Application Reference: 2025/0042

Site Address: 21 Salters Way, Penistone, Sheffield, S36 6UE

This application seeks full planning permission for a single storey front extension to a 2 storey detached dwelling.

End Elevation – Proposed Ground floor Extension 21 Salters Way Penistone

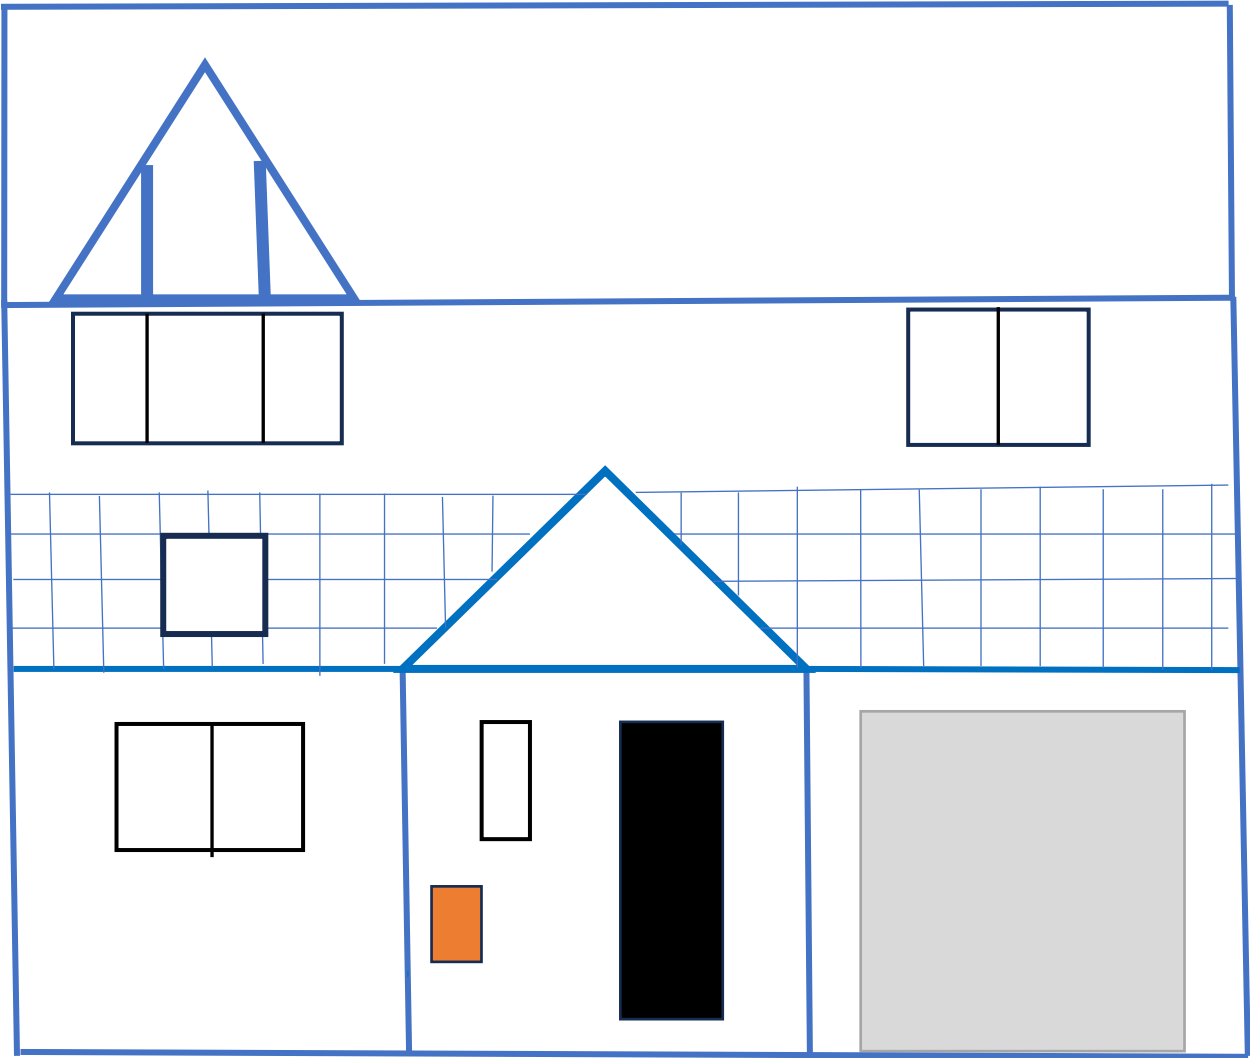
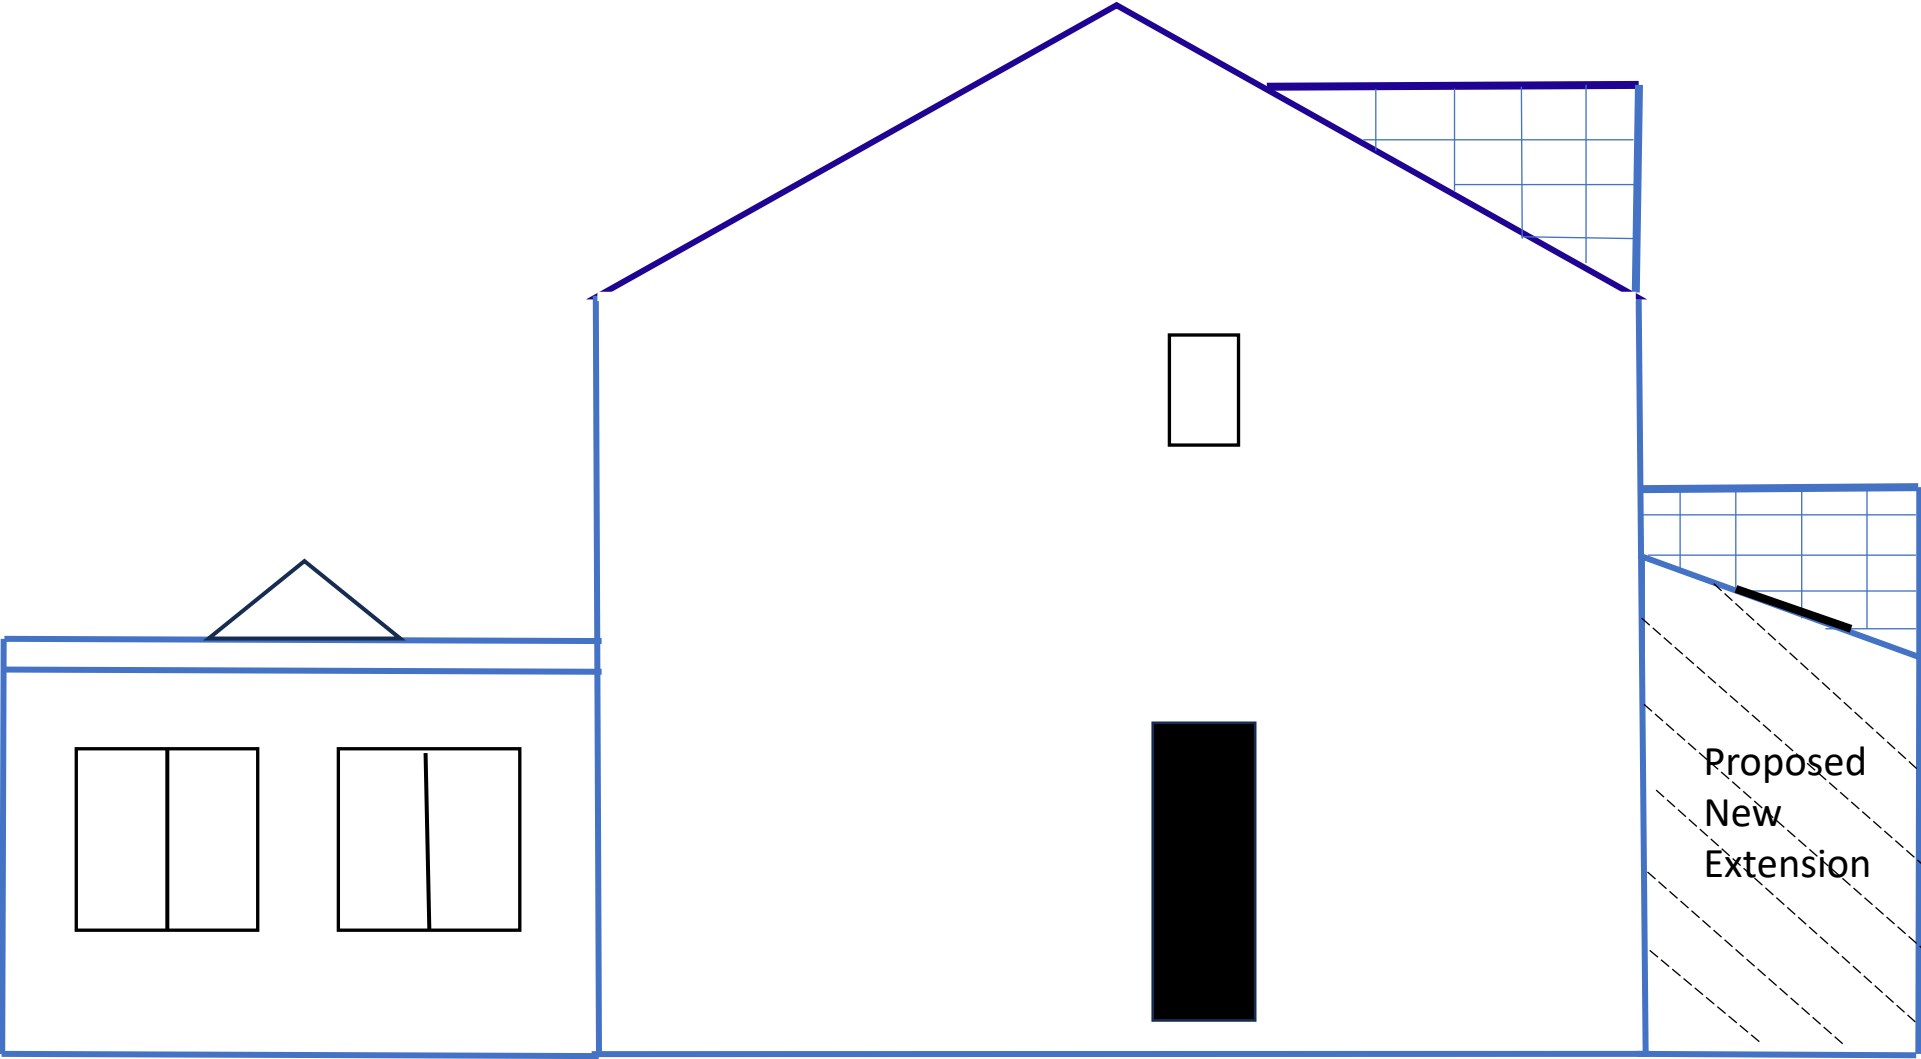
One characteristic of the proposal which deviates slightly from the original design but is a feature of other extensions across the estate is the proposed rooflight, located in the pitched roof of the proposed extension. Whilst the rooflight serves a practical purpose for allowing extra light in to the dwelling, as a design feature whilst it does not add anything positive, neither is it a significantly negative feature. It would therefore be considered that the rooflight would have little or no impact on the design or character of the dwelling and street scene.

Plan View – Proposed Extension Ground Floor 21 Salters Way Penistone

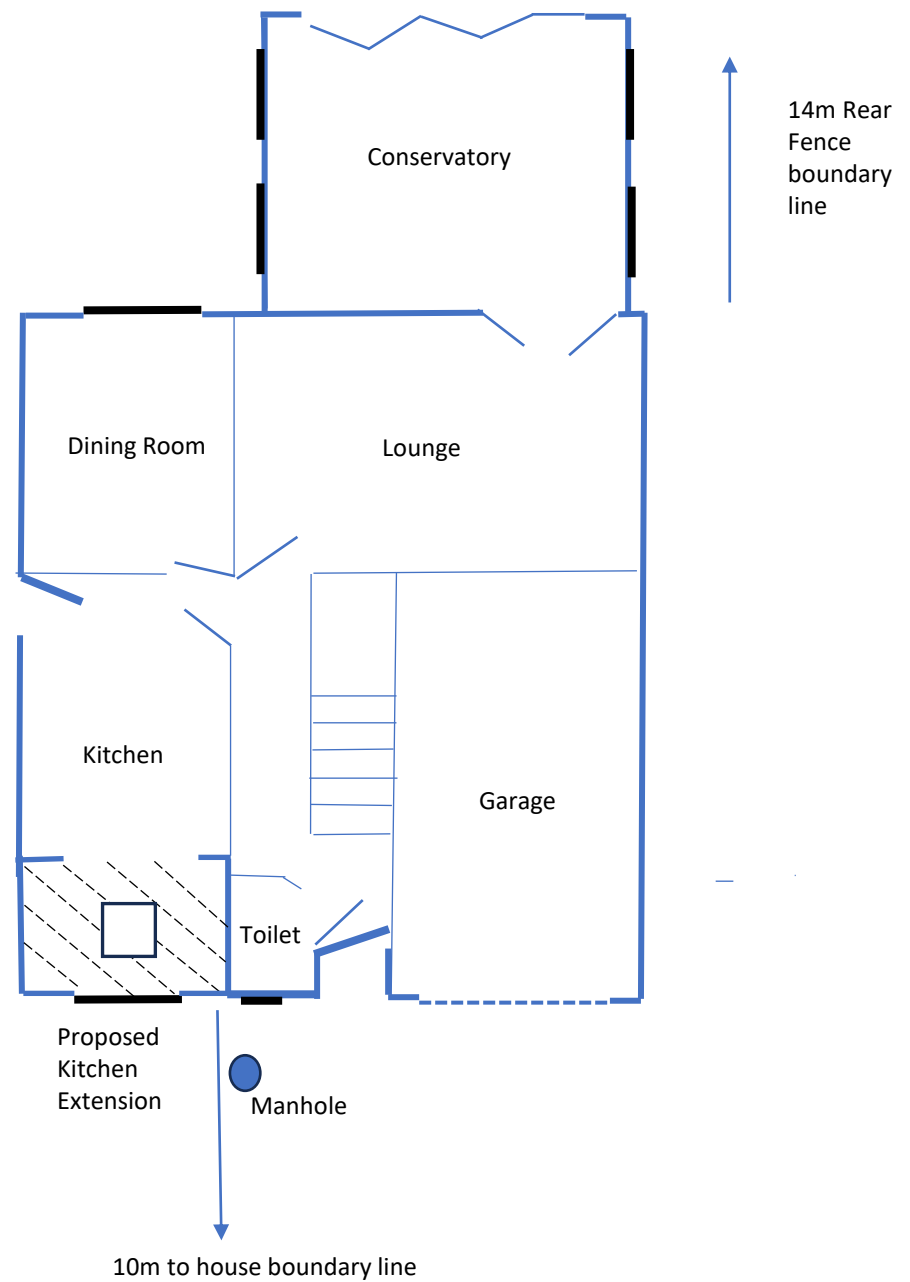
The proposal is of a small scale which is designed to harmonise with the character of the existing dwelling. Whilst there may be some aesthetic imperfections regarding the bonding of new and old brick work, overall the proposal would be considered to be of an acceptable scale and design and would be considered to have a limited effect upon the character of the dwelling and street scene, in accordance with local plan policy D1.

For both the walls and roof of the proposed extension, materials of a similar appearance are proposed to be used in the construction. Whilst this would not resolve the potential issue of the bonding of old and new materials, as discussed above, it would assist in maintaining the design and overall character of the dwelling whilst creating a symmetrical front elevation which would hopefully have a positive impact but otherwise would have little or no negative effect upon the scale design and character of the dwelling.
